Planning Application No: 3/2026/0433

Proposal: Proposed conversion from agricultural machinery store to holiday let.

Location: Rowan Cottage Old Clitheroe Road Hurst Green PR3 2YU

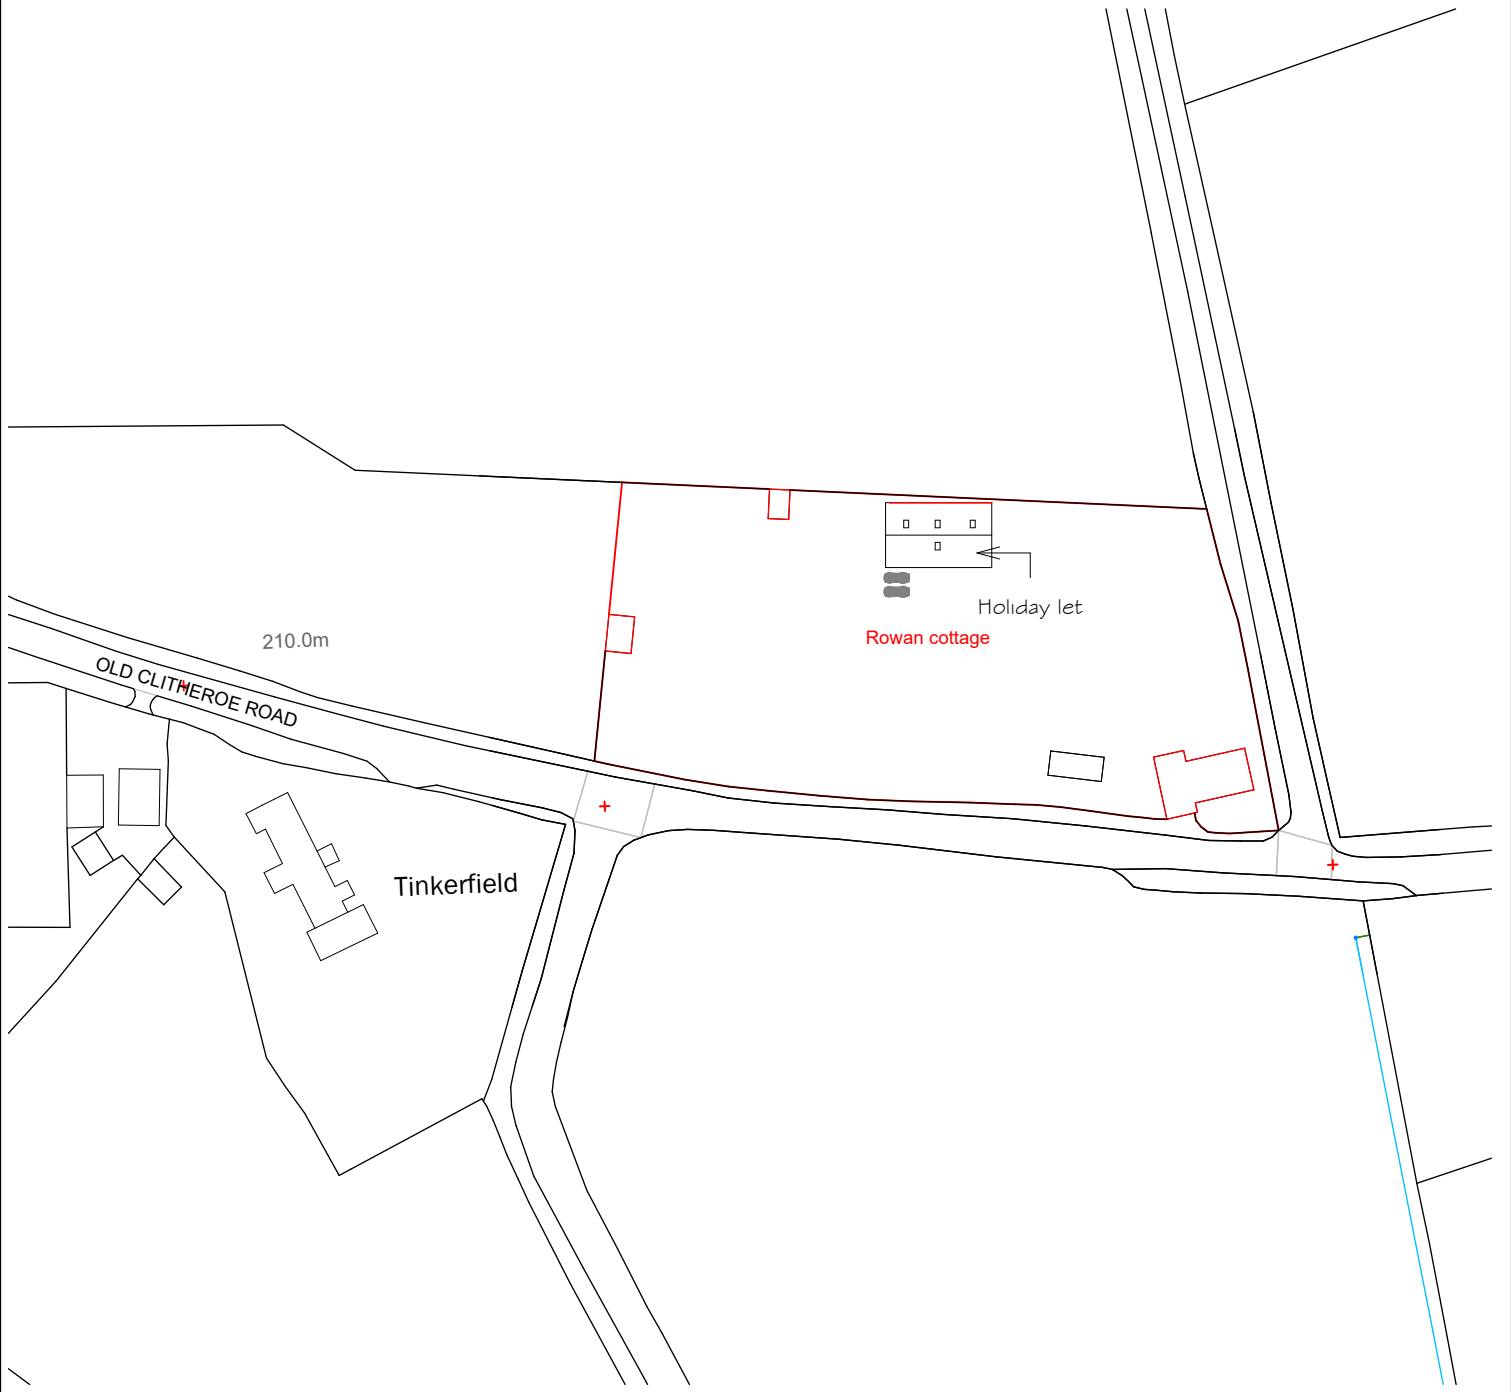
There is no change to the original access or vehicle parking proposed. Two parking spaces have been provided for this proposed 3 bedroom holiday let. This meets with parking standard requirements. The parking area must be constructed of a bound porous material .

- Prior to the first occupation a secure, covered cycle store shall be provided for a minimum of 3 bicycles. Reason: To promote sustainable forms of transport and aid social inclusion.
- The parking areas must be constructed of a bound porous material and created before first occupation up until the life time of the dwelling exists in their proposed state. Reason: To ensure that satisfactory parking is provided before the dwelling hereby permitted becomes operative.
